Consultation Response from KC, Lead Local Flood Authority
2025/91781 Bradley Villa Farm, Bradley Road, Bradley, Huddersfield, HD2 2JY
Discharge of details reserved by conditions 9 (cycle parking), 10 (electric vehicle charging), 11 (waste storage and collection), 12 (temporary drainage), 13 (drainage scheme), 14 (flood routing), 15 (Phase II report), 19 (external materials), 20 (boundary treatments), 21 (external lighting), 23 (BNG assessment) and 24 (Biodiversity Gain Plan) of previous permission 2023/92887 for change of use of egg production unit to research and development or industrial uses falling within E(g)(ii) and (iii) Use Class, and associated elevational alterations and provision of access, gates, forecourt, parking areas and landscaping
Date Responded: 7th April 2026 Responding Officer: Paul Farndale Responding Ref: 1

Condition 13 – Drainage Details

TITLE		ATTENUATION BASIN SECTIONS	
PROJECT		BRADLEY VILLA FARM	
CLIENT		MR R KERSHAW	
DRAWING STATUS		PRELIMINARY	
Scale	Date	Drawn	CR
1:250 @ A1	MAR 26	Chk.	MI
Drw. No.	2489/01/SK04		Rev

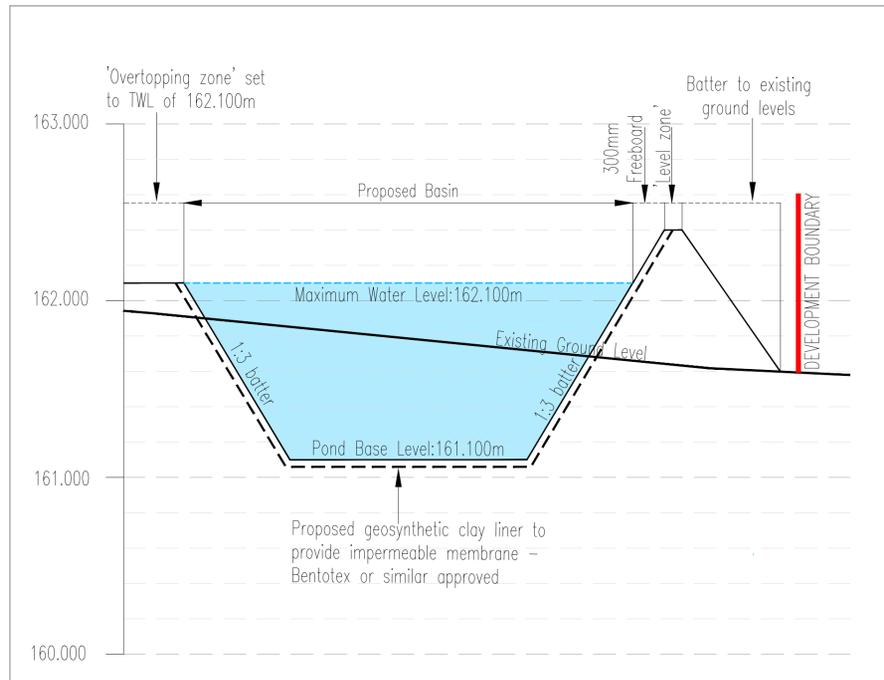
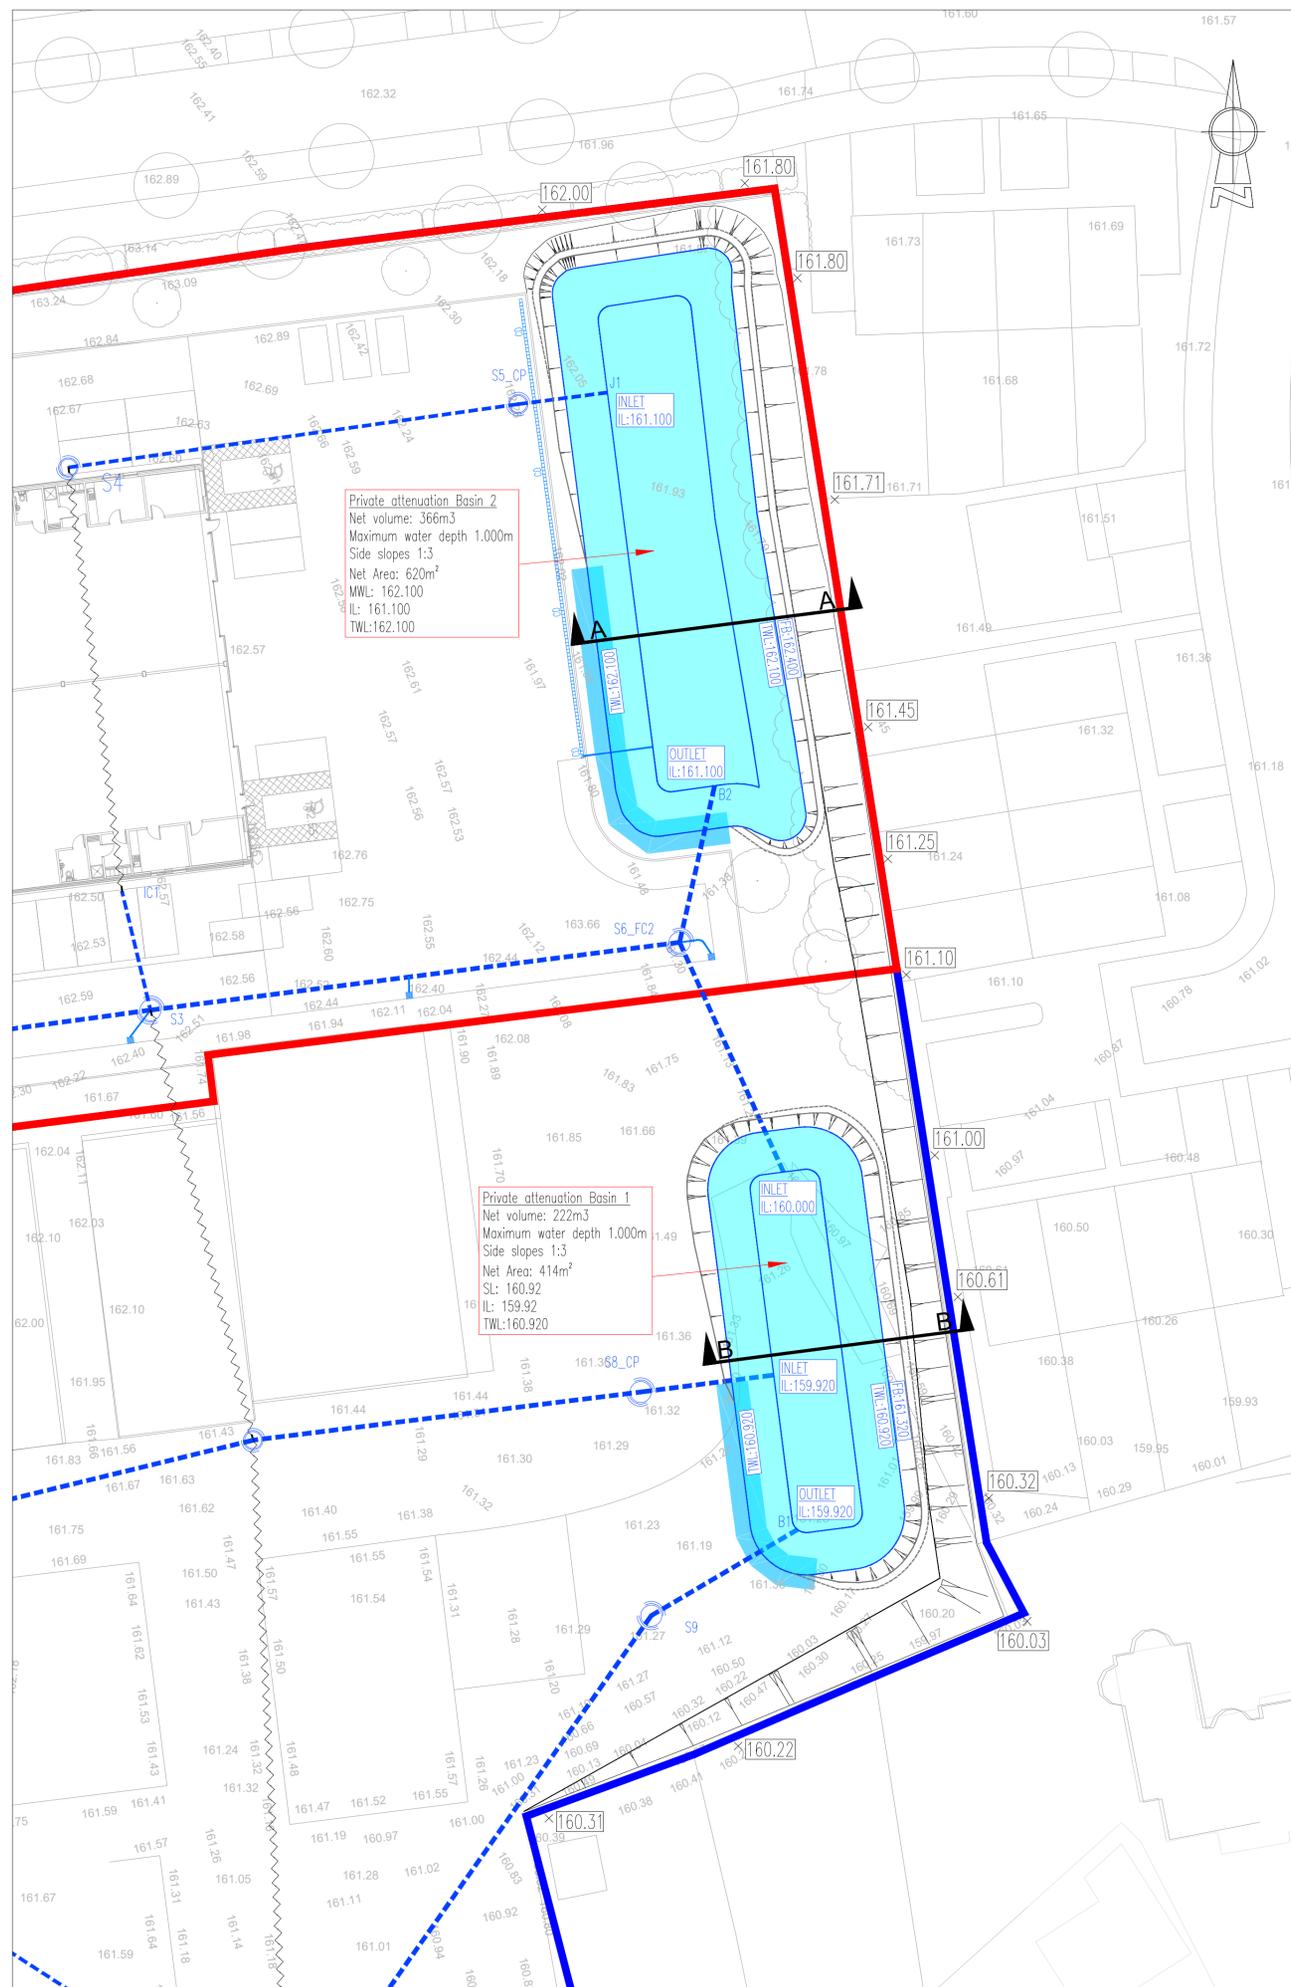
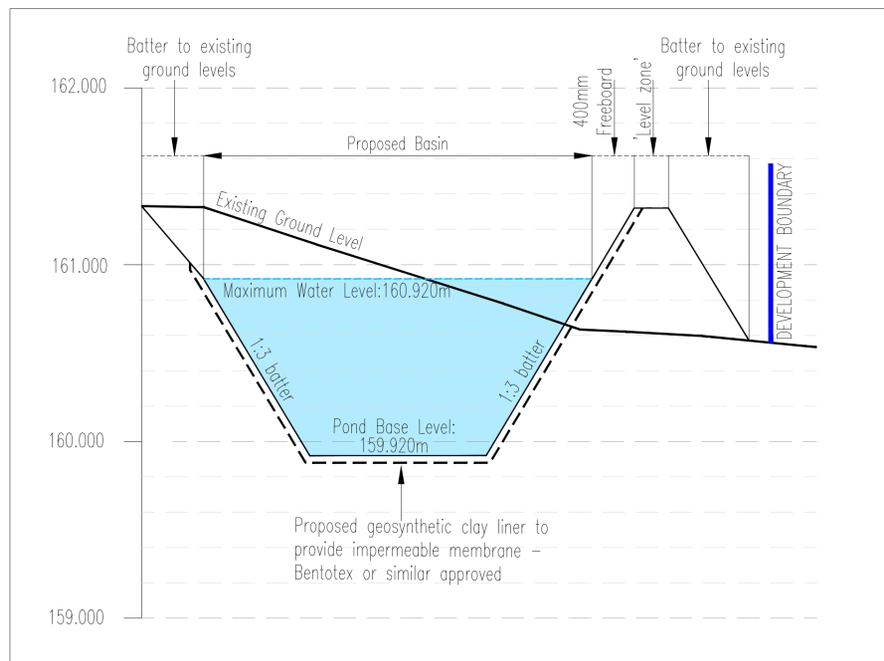
Basin plans and cross sections have been supplied.

We recommend that this condition can be discharged.

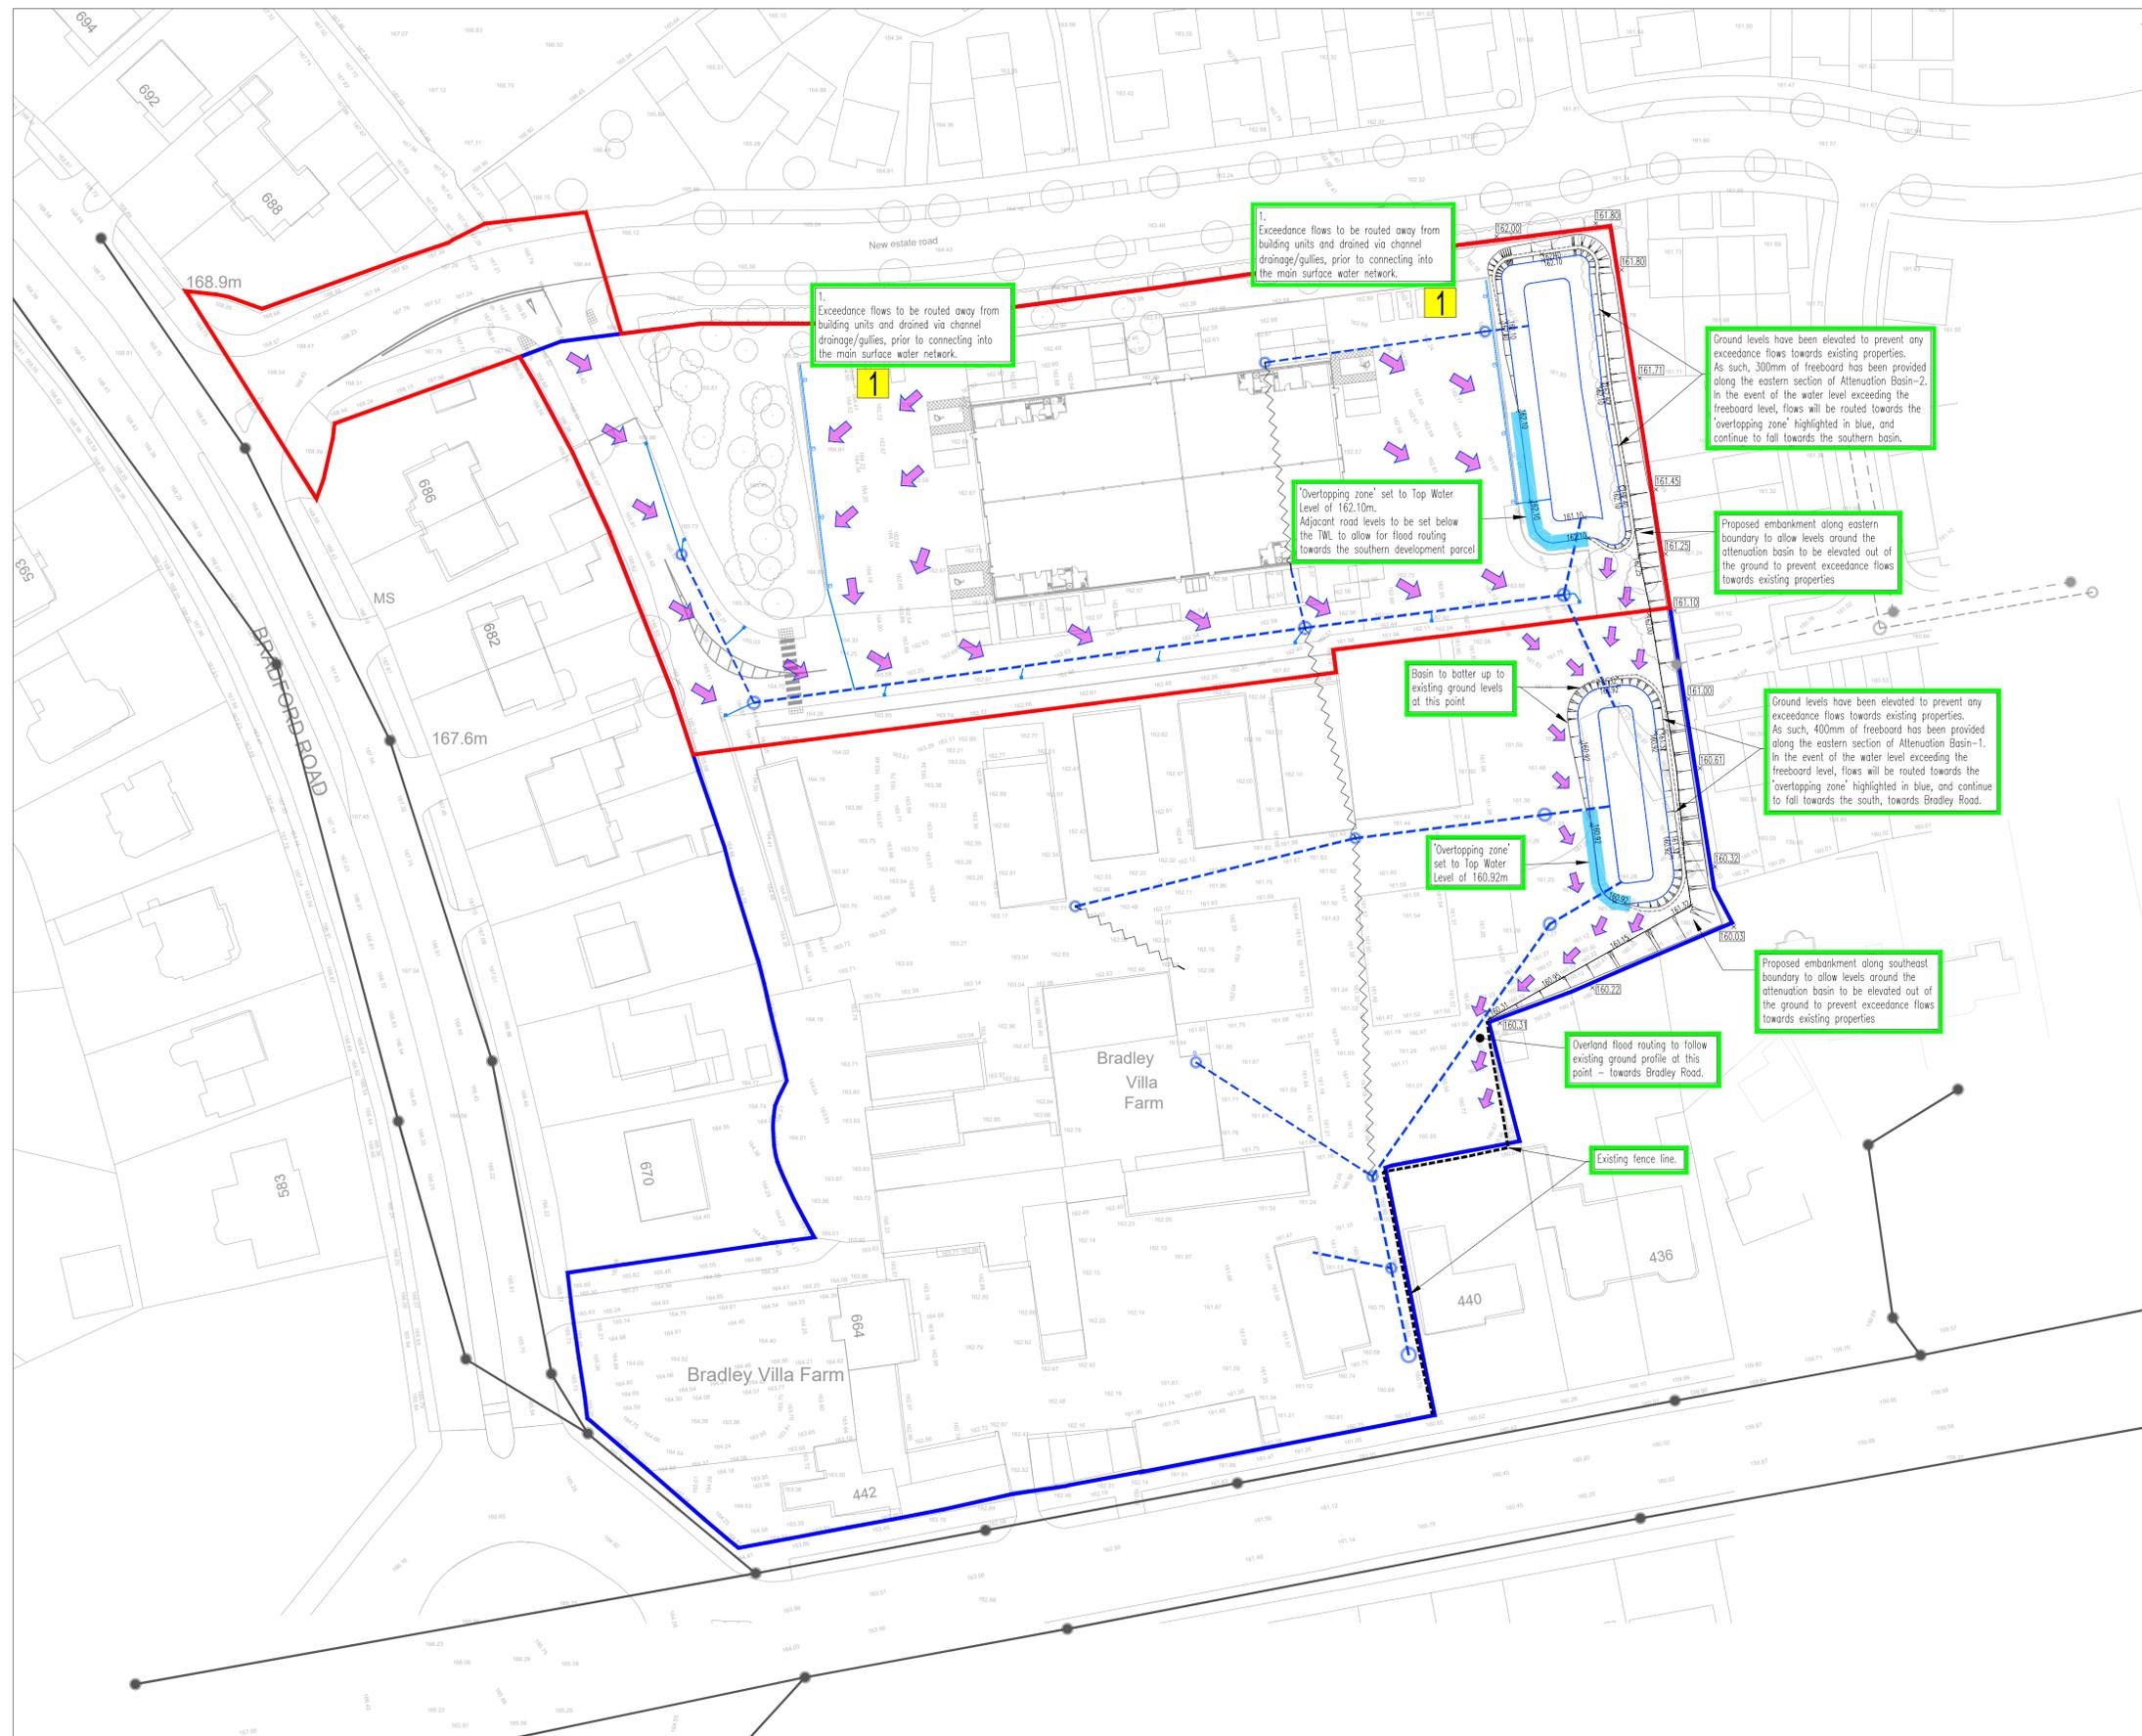
A flood routing drawing with bunds to protect existing properties for blockage scenarios and exceedance events has been submitted.

We recommend that this condition can be discharged.

TITLE **DRAINAGE STRATEGY**  
**PROPOSED – NETWORK B**  
**SHEET 1 OF 1**

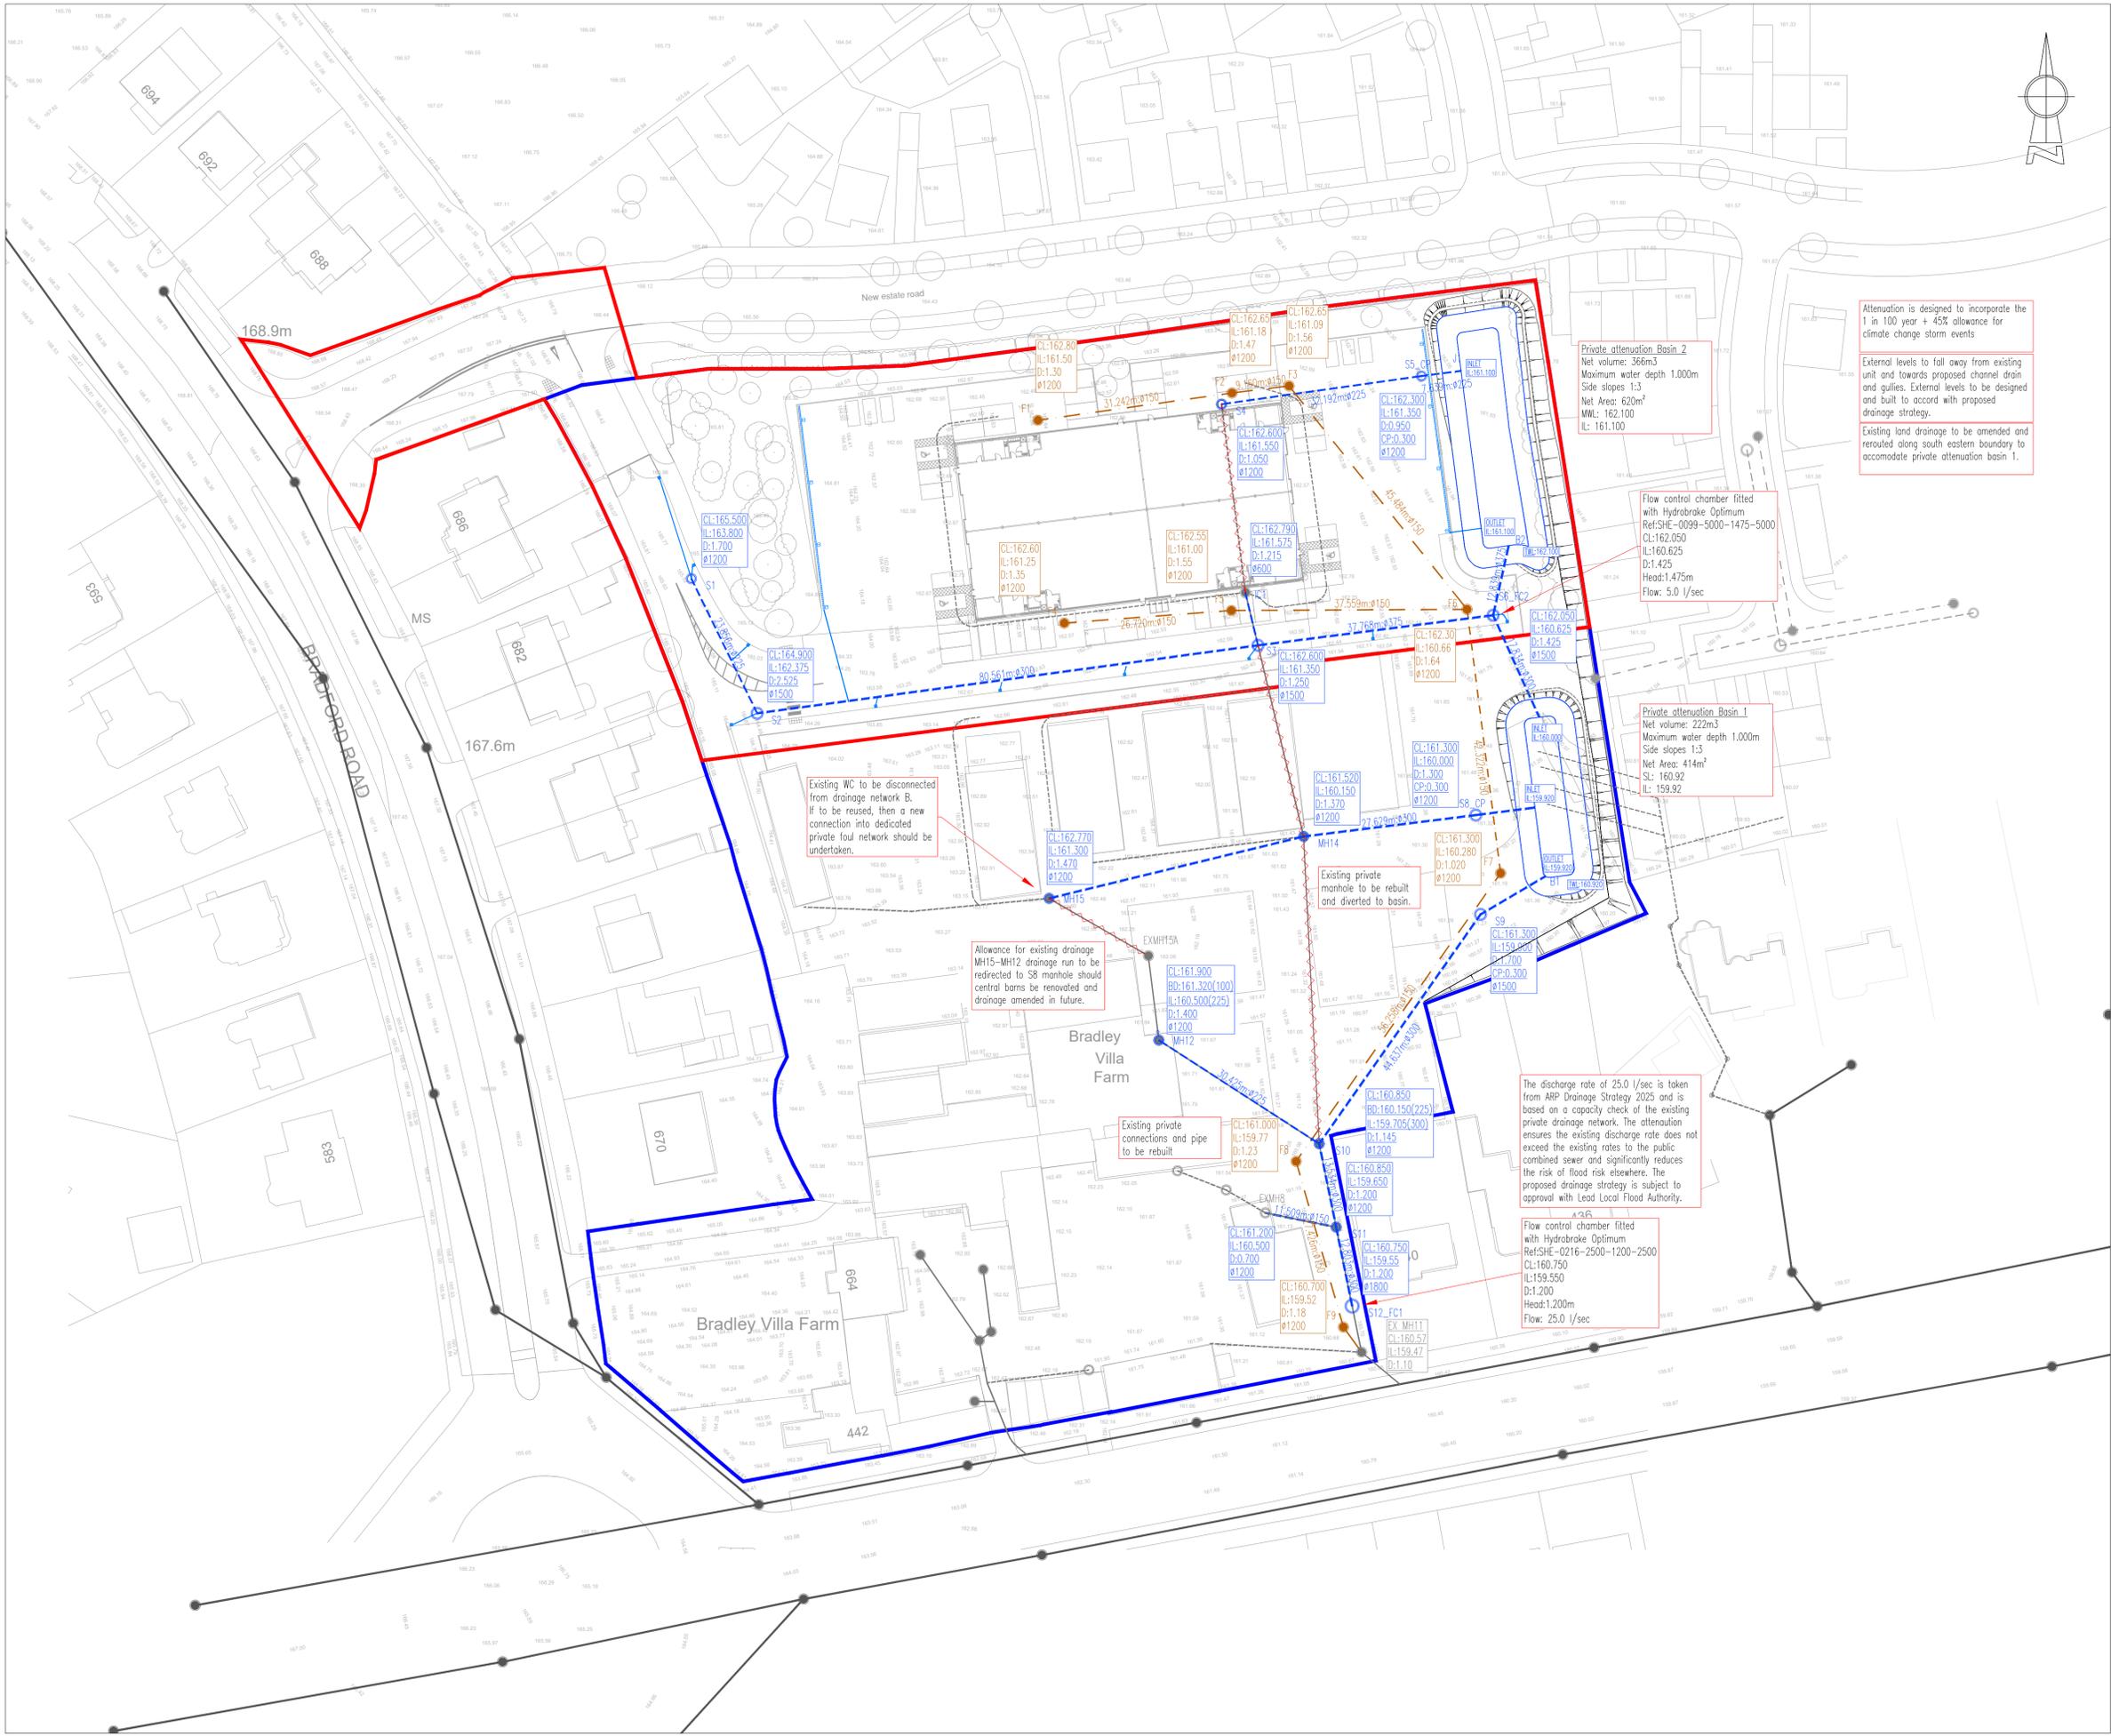
Drawings demonstrating hardstanding contributing to flows has been supplied.
